Planning Officer: Mr A Wood

Planning Application Ref: A/104/19/RES

Location: Crete Nursery, Dappers Lane, Angmering, BN16 4EN

Description of works: Approval of reserved matters following A/178/17/OUT for the demolition of existing outbuildings with retention of existing dwelling & erection of 6no. dwellings

Plate 2: Garden & Boundary Fences

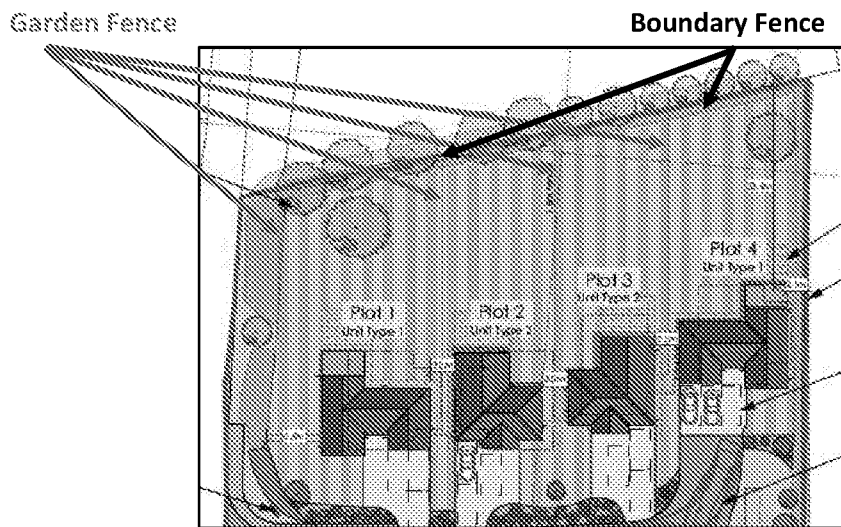
Para.3 - The AMS does not cover in enough detail what is happening with the boundary fencing and garden division fencing within the RPA of the screen of hornbeam trees to the north and off-site – mitigation measures and methodology required here.

Plate 4: RPA of T07 in Relation to the Existing Hardstanding Access Track
Dominant Category A Oak Tree (T07) With 9.15m RPA Superimposed

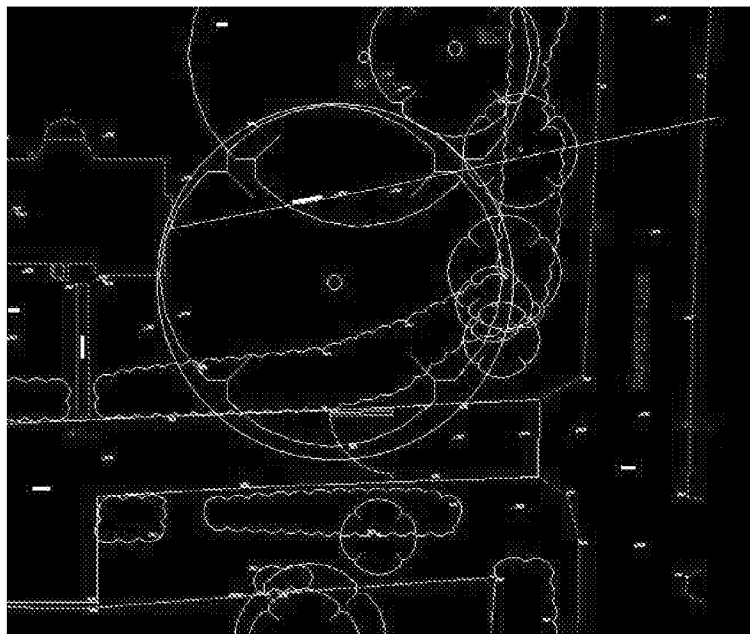
Para.4 – The AMS does not detail exactly what is happening and the mitigation measures and methodology required here for any revisions to the access drive (widening or resurfacing) that appear to be taking place.
